DECISION DELEGATED TO HEAD OF PLANNING

Application No: H09-0234-25 Applicant: George Thompson Farms Ltd.

Proposal: Erection of 2 Calf Barns

Location: Hurn Bank Holbeach Hurn Spalding

Pre-Development Plan Baseline Map

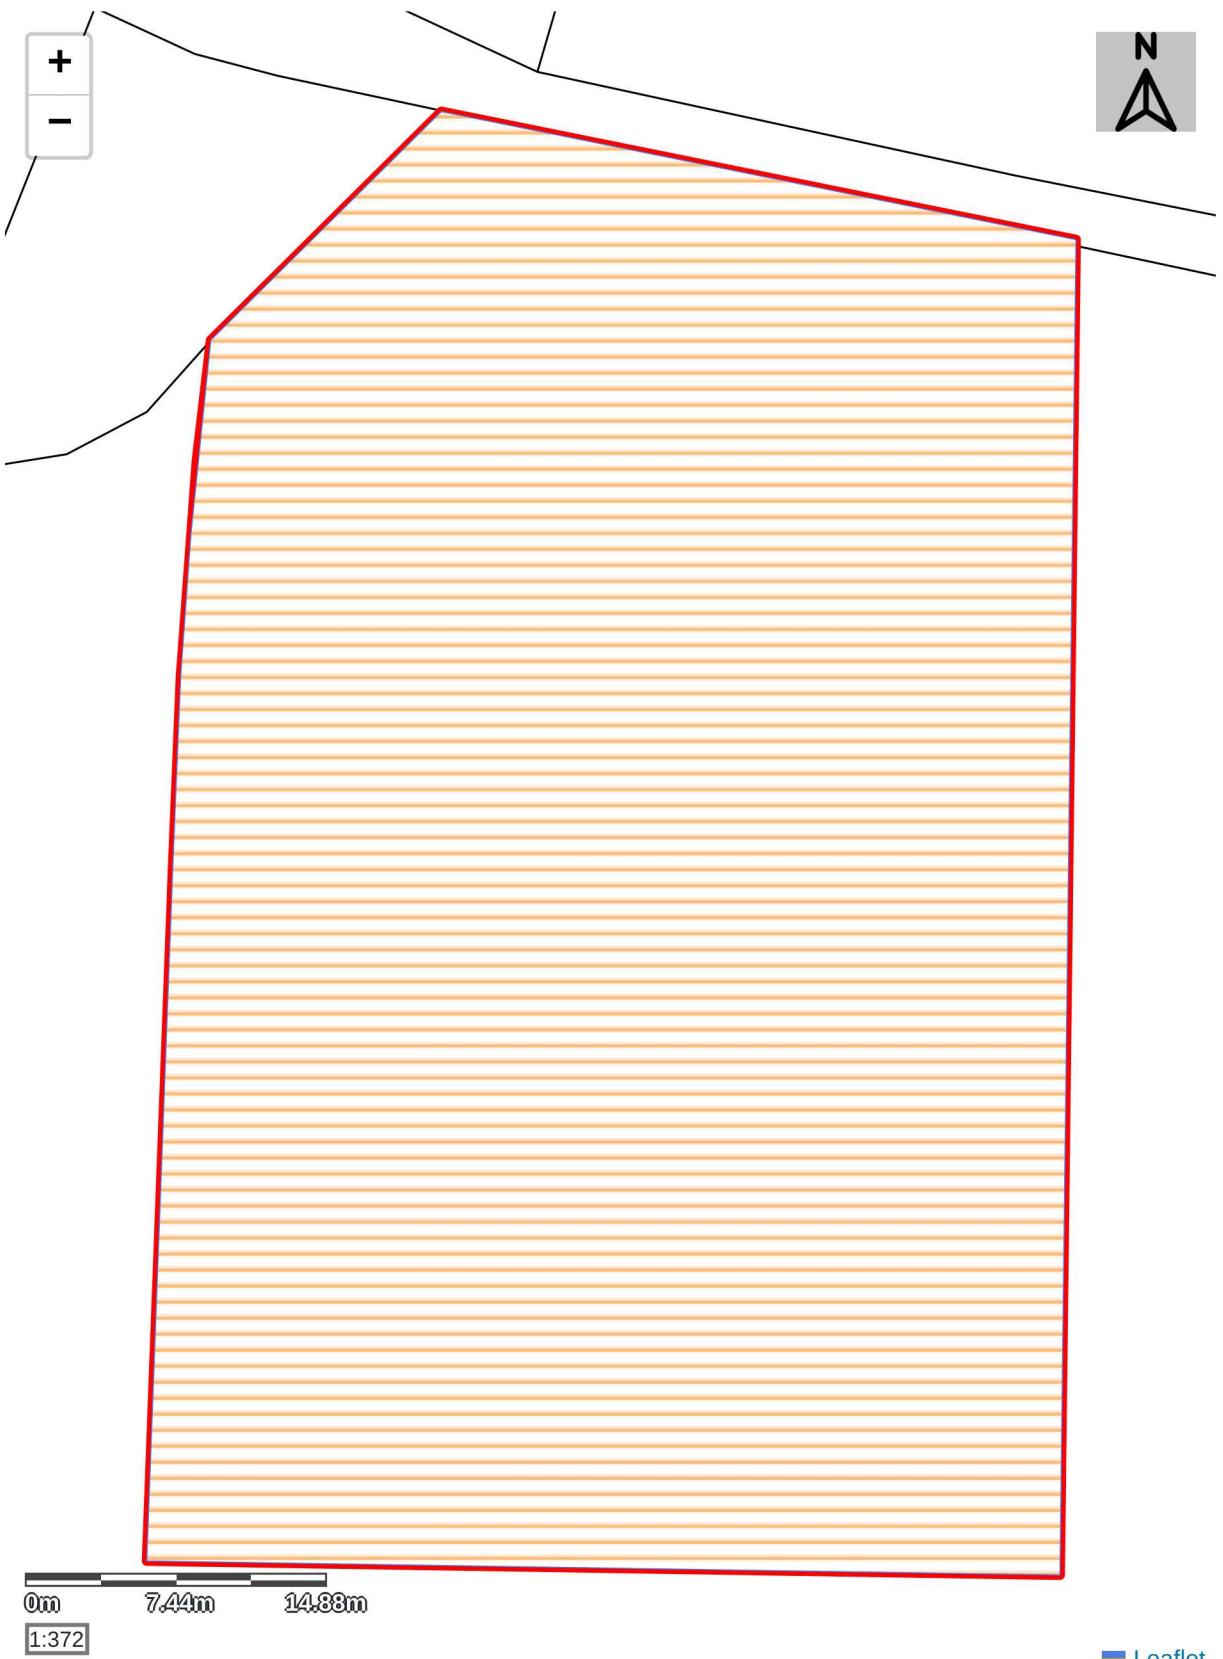
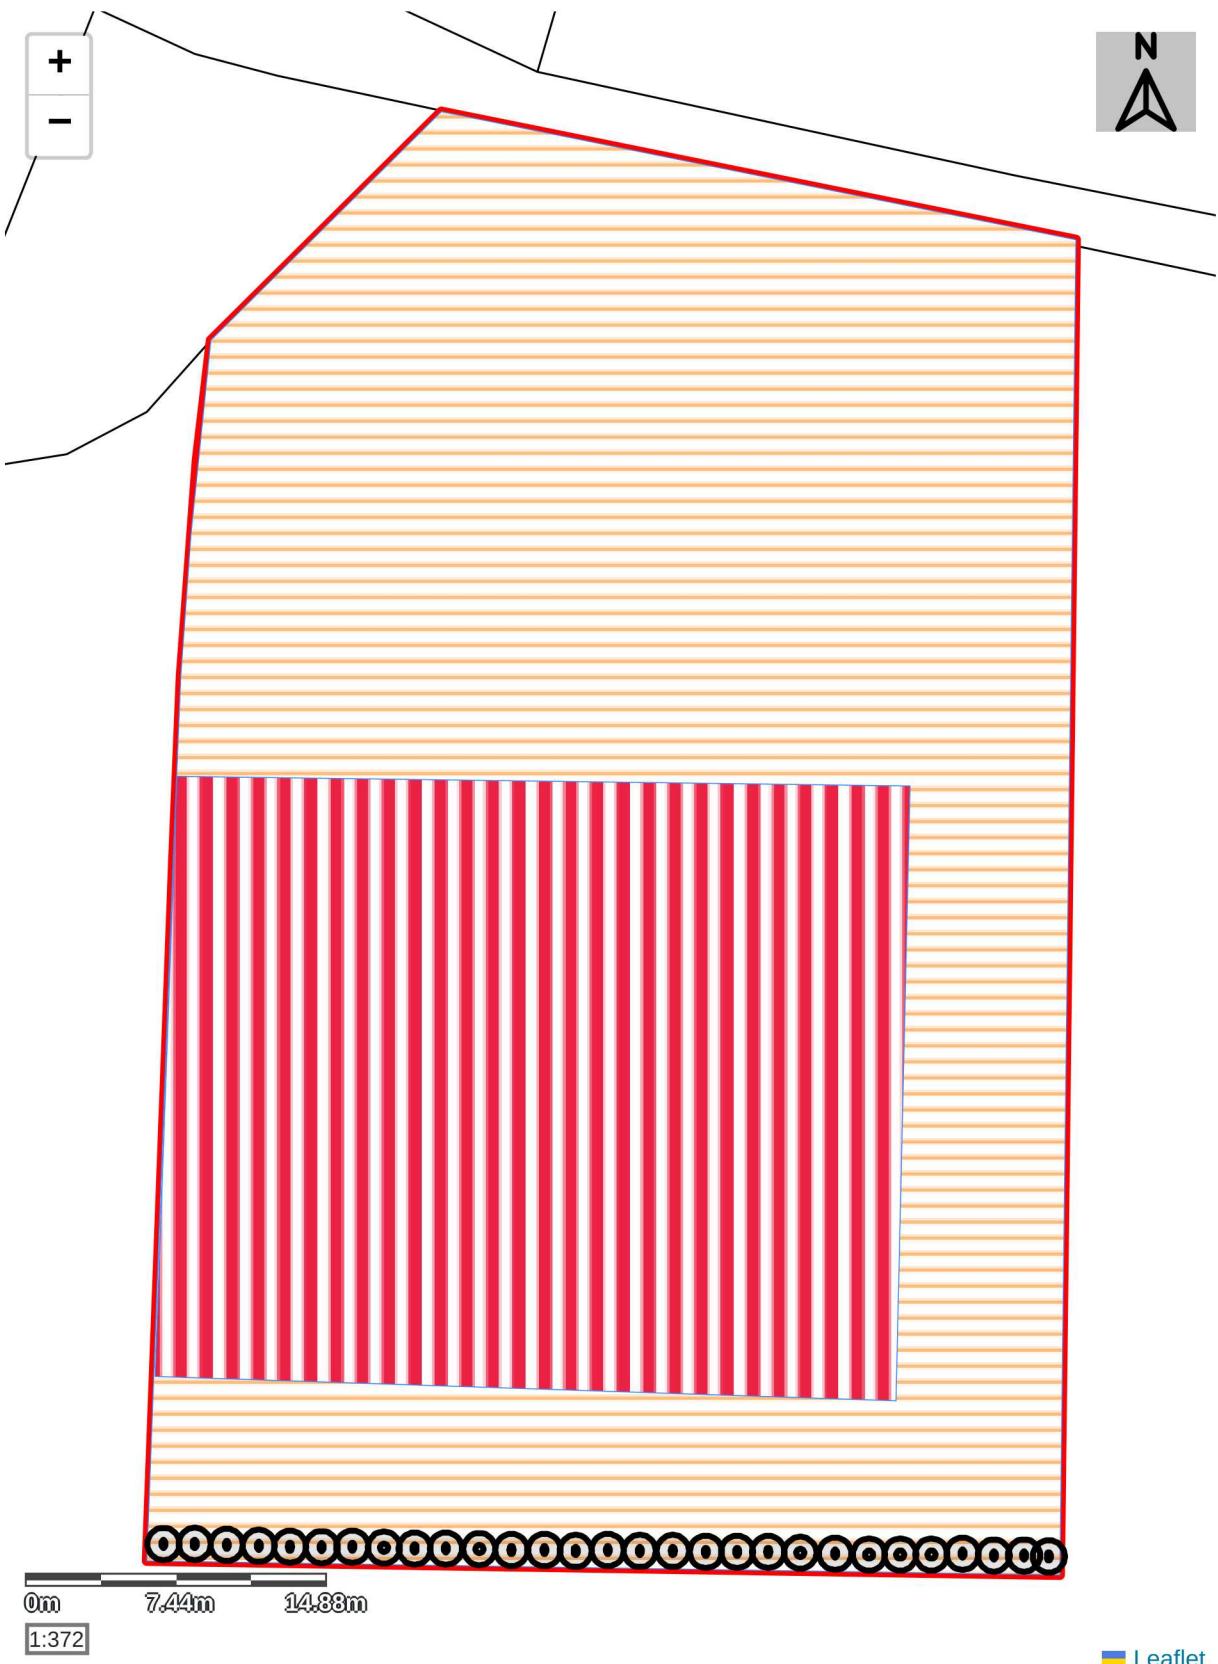
- 2). The baseline habitat in the red-line boundary is currently classified as "Modified grassland" in the metric. However, looking at various satellite imagery between 1985-2025 indicates that the site was primarily within an arable rotation up until very recently. Therefore, it is strongly suspected that this area would be much more accurately classified as "cropland - cereal crops" in the baseline metric calculations. This reduces the estimated baseline biodiversity value of the site, which results in the proposals achieving an estimated 32% net gain in biodiversity value (after making the tree correction above in point 1). Therefore, it is queried how long the site has been managed as a "grassland" and if it has been planted as arable up to last year, it is advocated that it is classified as such in the metric.

An amended Small-sites Metric, Pre-Development Baseline Map and Biodiversity Gain Plan form were subsequently submitted by the applicant to accord with the requirements of the Council's Ecologist to ensure the development achieves the mandatory 10% biodiversity net gain.
